Submissions Report (MOD-3)

State Significant Development (MP07_0048-MOD-3)

Enviroking Liquid Waste Facility Project

843 John Renshaw Drive, Black Hill

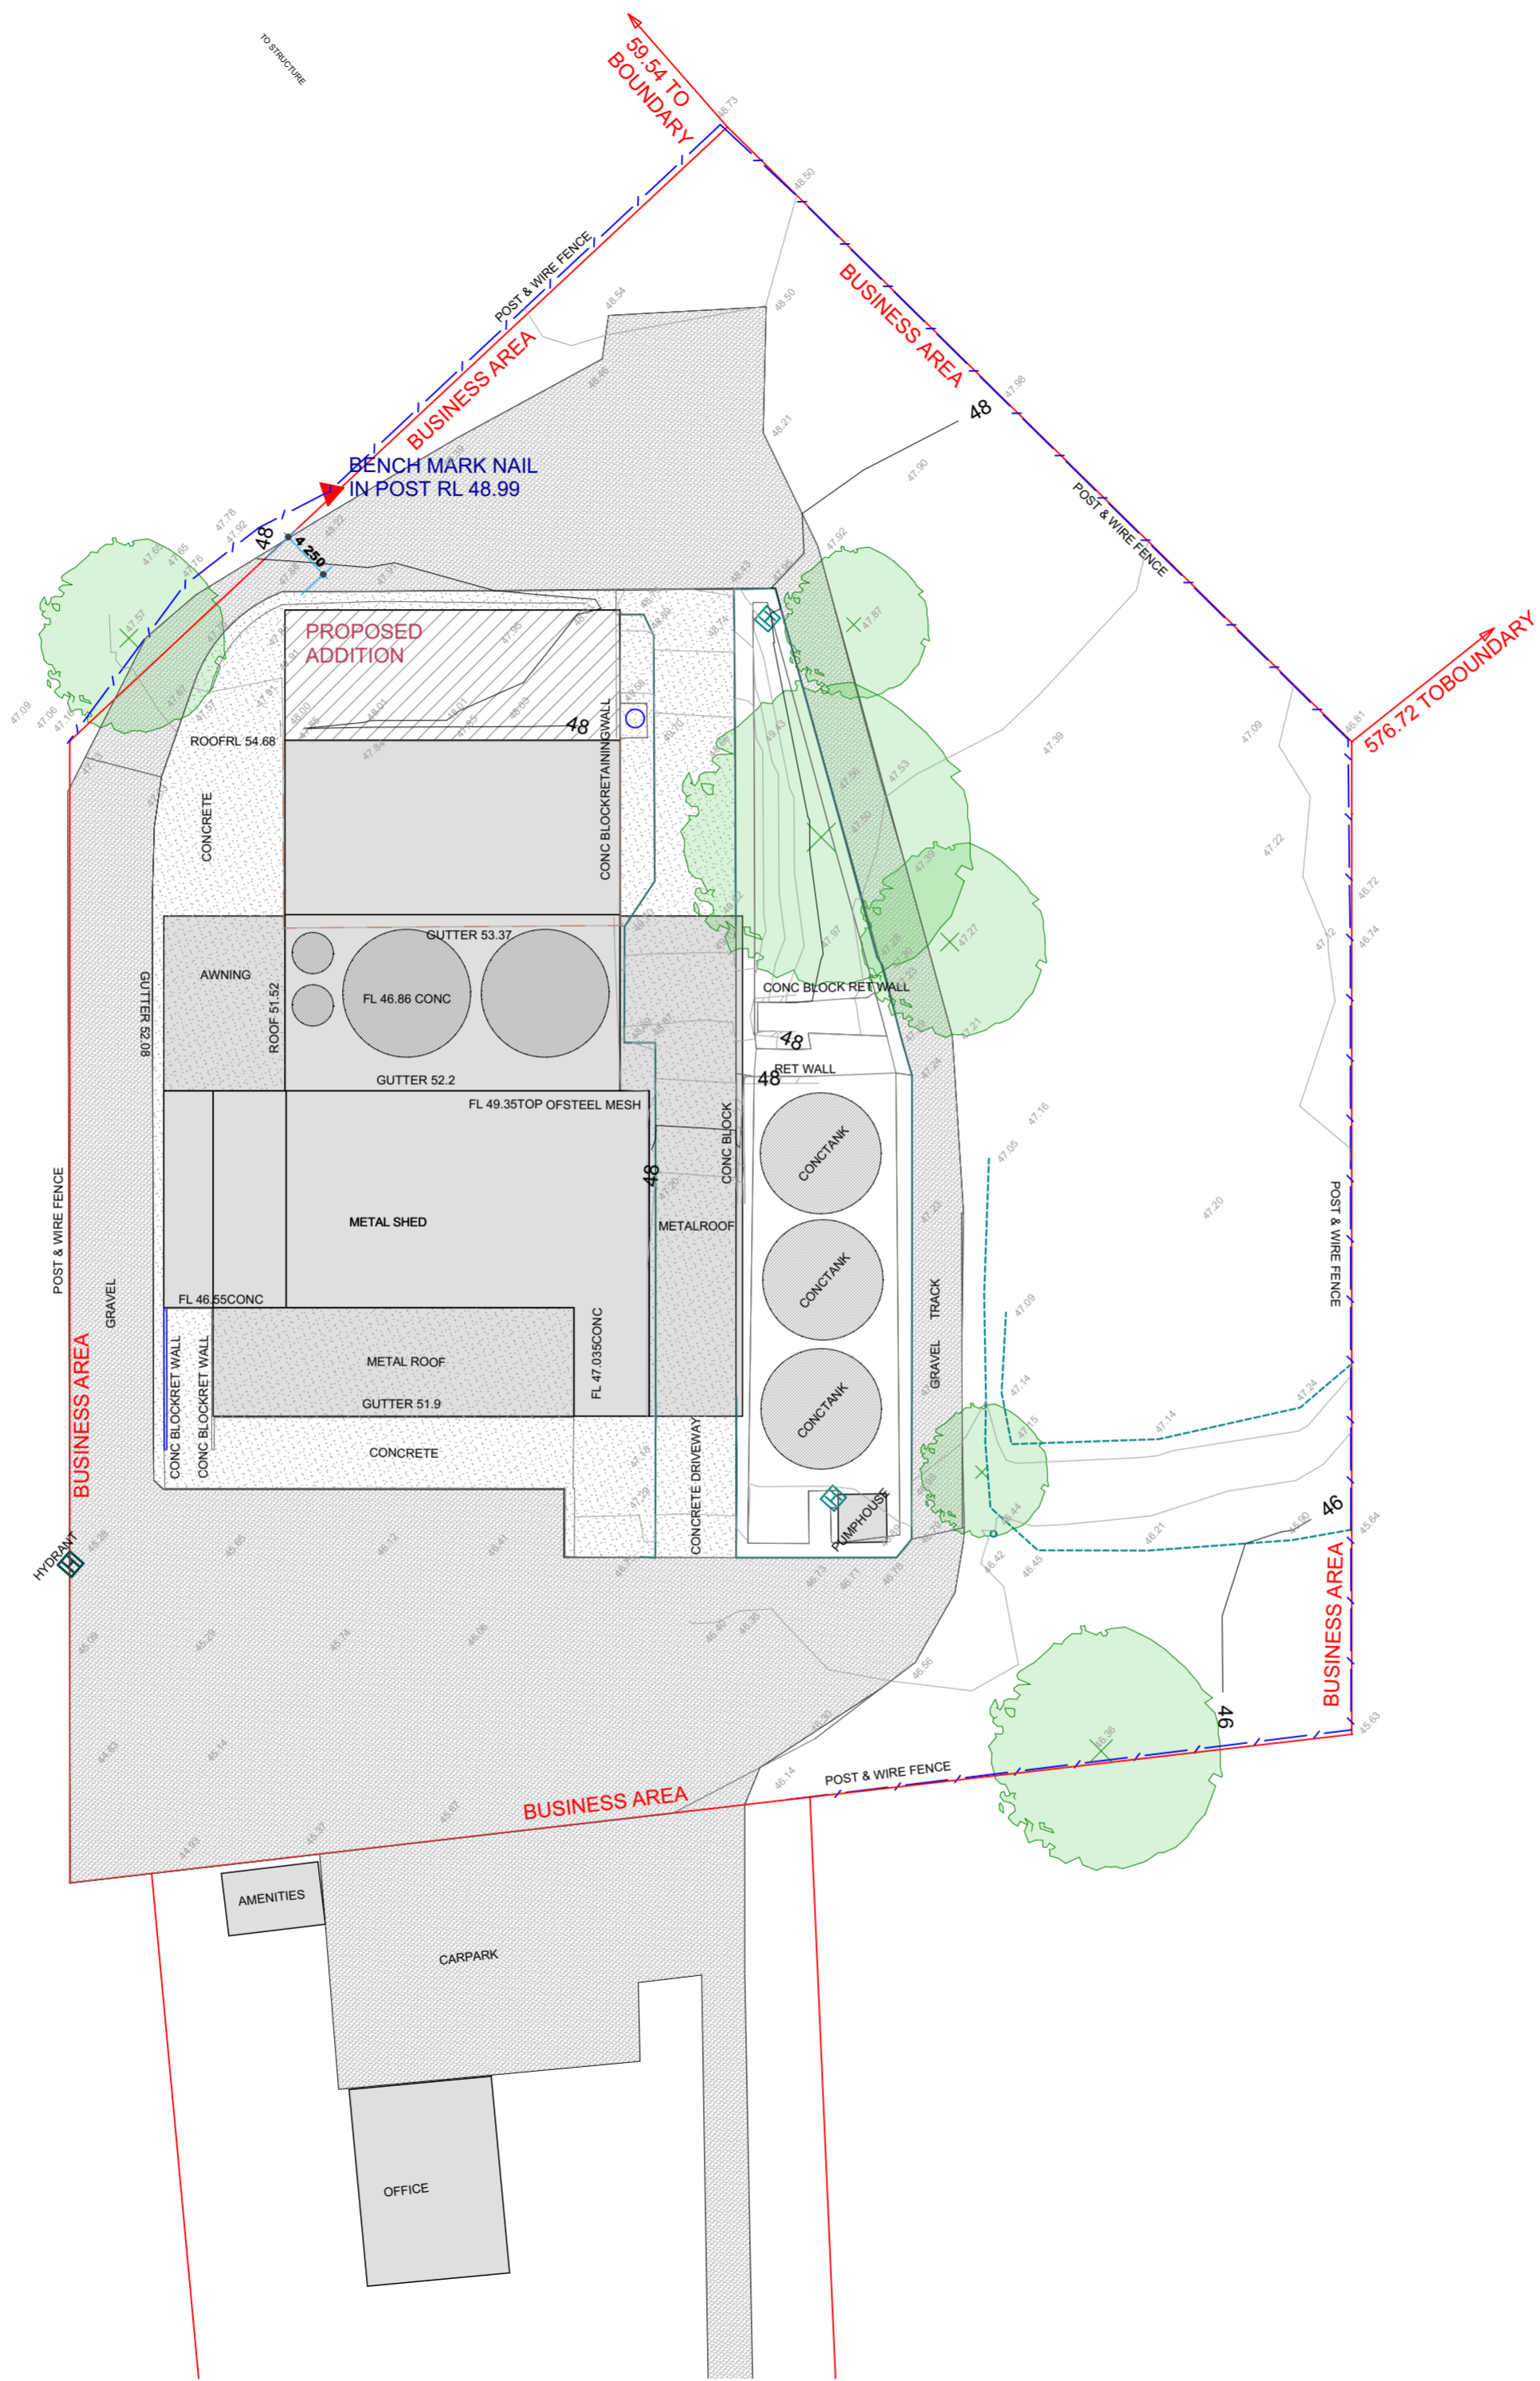
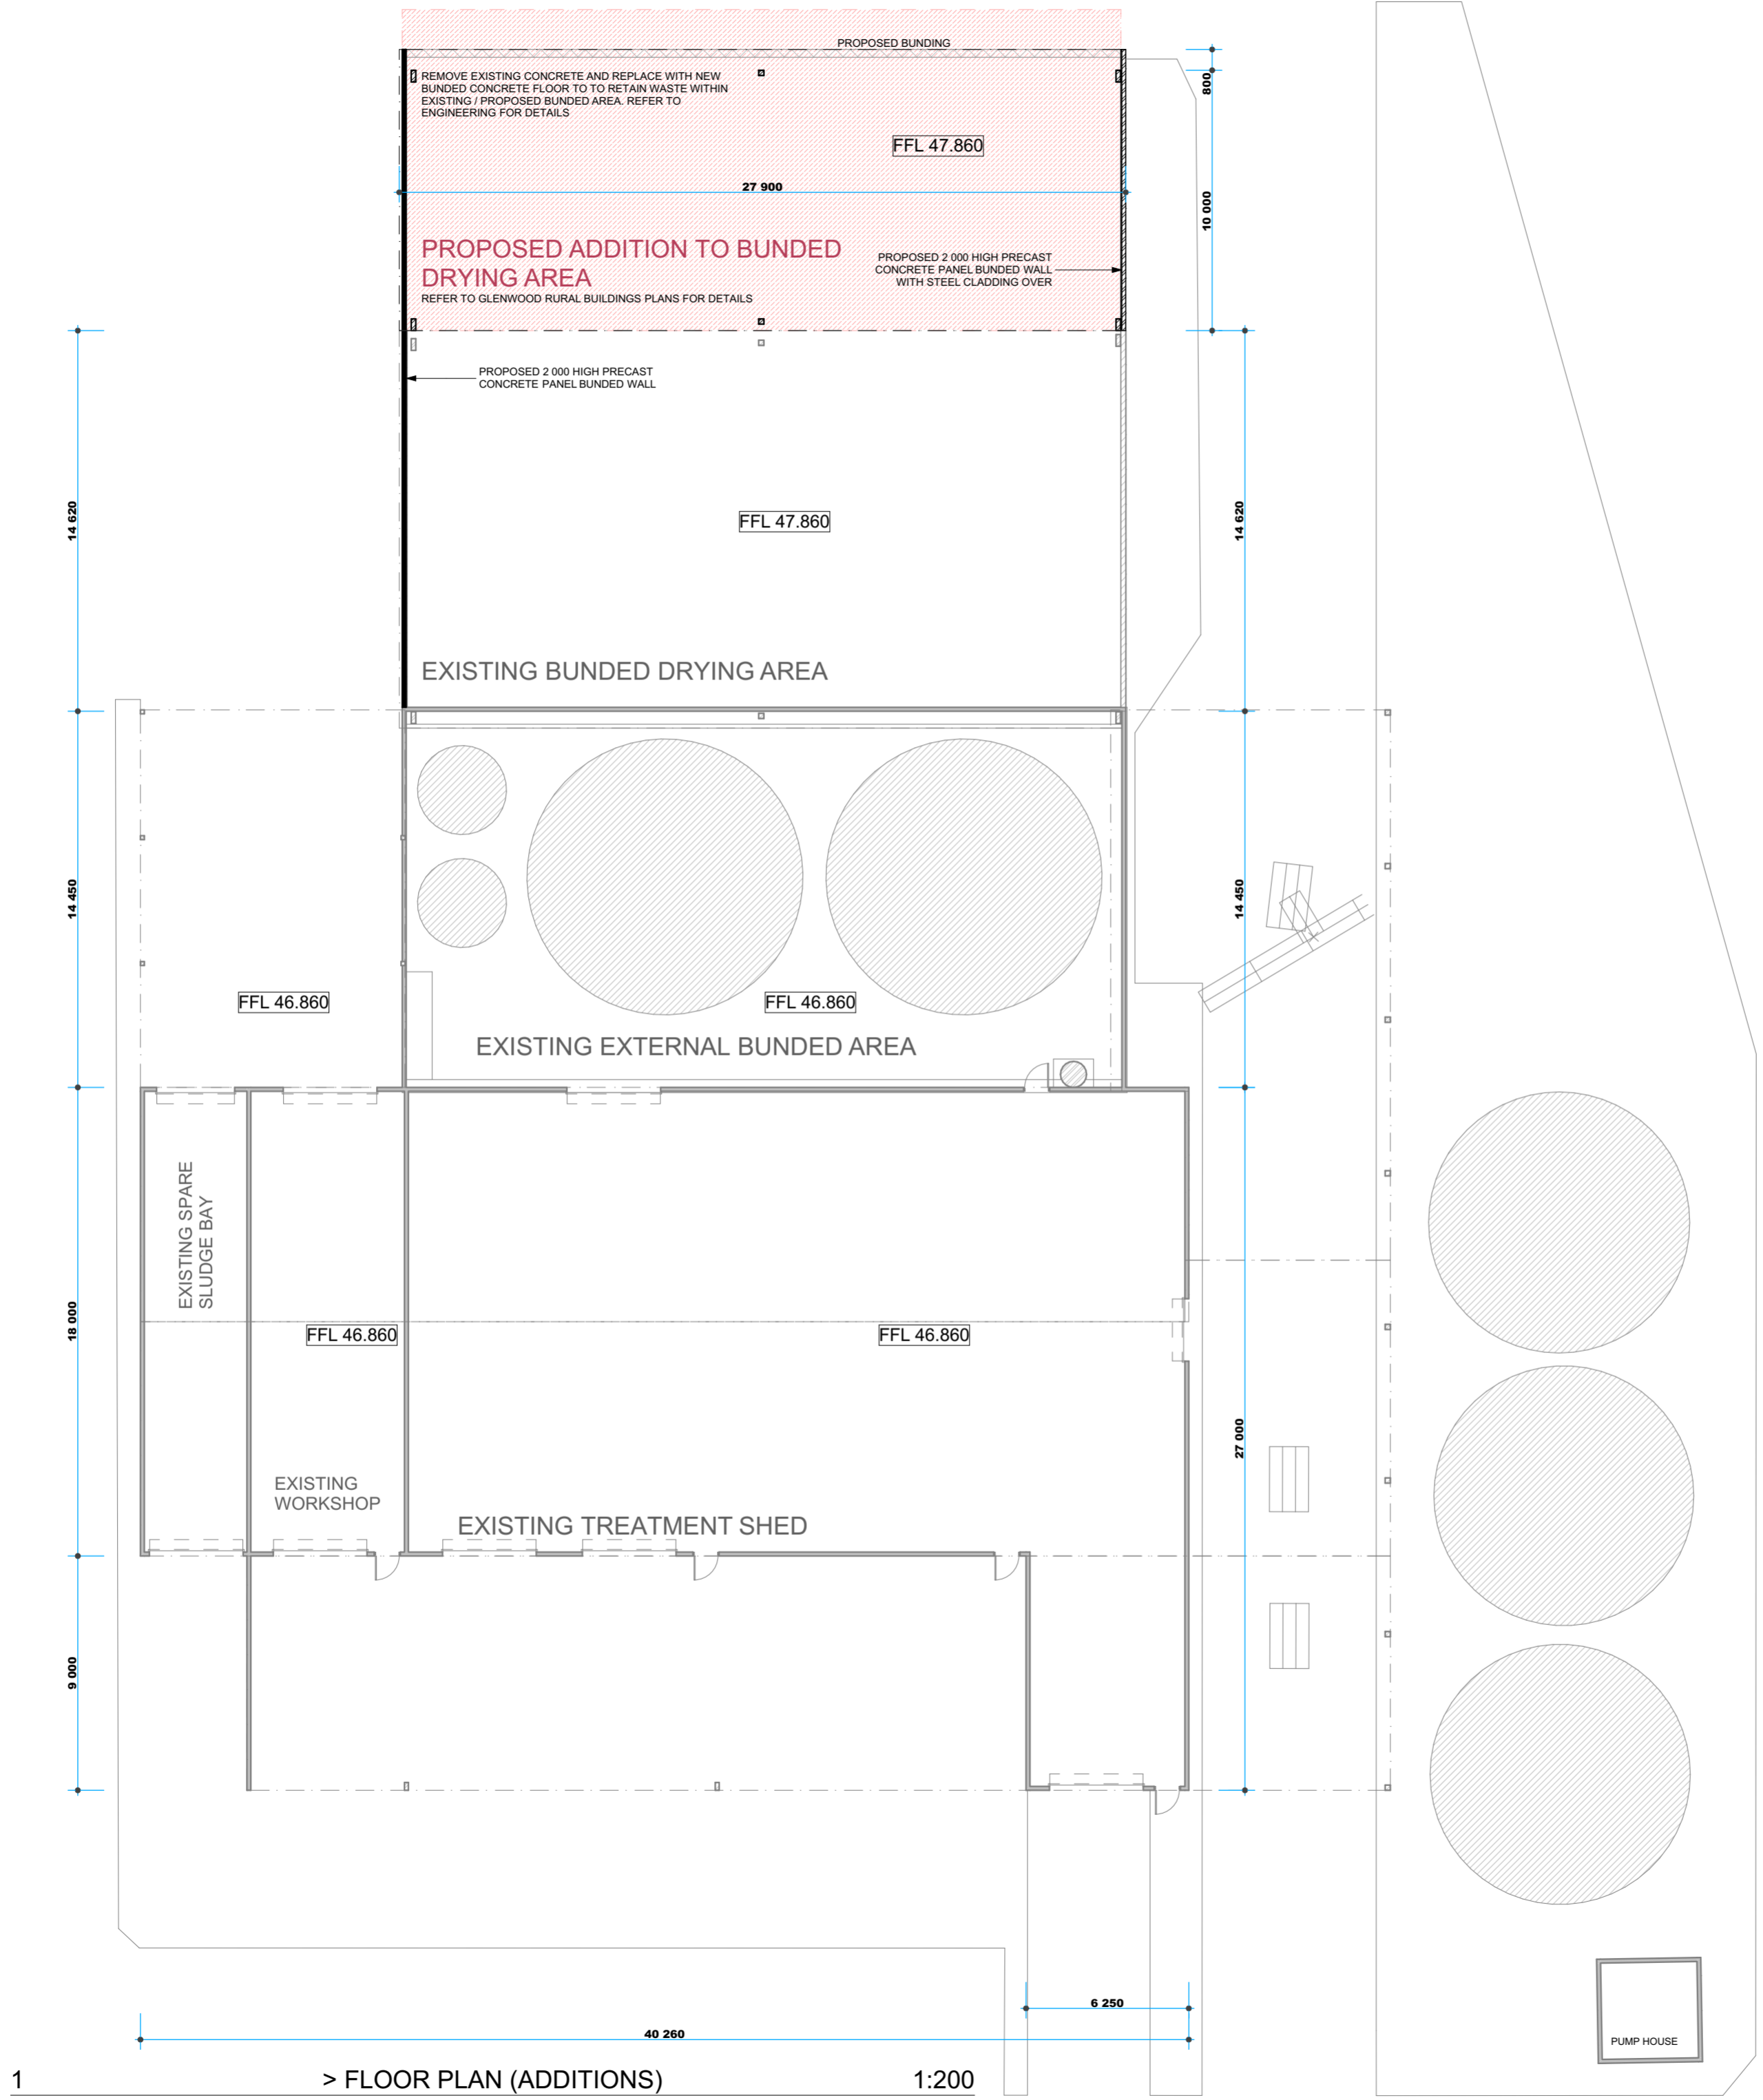
Table 4 Department of Planning and Environment (EPA)			
Item #	Issue	Response	Reference
4.1	The EPA notes that the Review Documents addressed the key information requirements and indicated little to no impact of the modification to surrounding land users or stakeholders. However, the EPA is concerned about the capacity for solid waste storage from the increased throughput. The EPA has recently inspected the Premises and observed that a solid waste by-product material stored at the rear/side of the buildings was able to be impacted by rainfall. The EPA observed that waste woodchip is stored at the rear of the buildings uncovered; leachate from woodchip can be ecotoxic. There are no walls to prevent rainfall ingress to some key areas, and storage stockpiles can encroach onto uncovered areas, causing the potential for runoff from waste stockpiles to flow into the stormwater system. The EPA has been advised by Enviroking that since our inspection wastes inside the building have been "pulled back" to prevent them being impacted by rainfall. The EPA proposes to negotiate a Pollution Reduction Program (PRP) under the Licence requiring: the covering of the rear storage area; the enclosure of certain walls of the building; and the regrading of hardstand to prevent any spills from entering the stormwater system.	In response to the EPAs concerns regarding the impact of rainfall and potential run-off into any stormwater system, the proposal has been amended to extend the rear awning to cover the existing hardstand area and enclose the sides of this space. This addition is to be constructed of a low precast concrete bunded wall with steel cladding above and steel panel roofing. The rear section of existing concrete will be reformed to create a bunded northern edge to prevent any run-off with the bunded area being directed to an internal pit collection with any wastewater contained and treated within the facility before off-site disposal.	Amendment Report (Mod 3) – Section 2.6 Appendix A and Appendix B

In response to EPA's concerns regarding the potential for adverse run-off from the solid waste storage area at the rear of the site, the proponent has amended the application to include alterations and additions to the rear hardstand area.

These works consist of the extension of the rear awning to cover the existing hardstand area and enclosing the sides of this space as well as the installation of bunding along the northern edge of the hardstand to prevent run-off. These works are detailed in the Amendment Report.
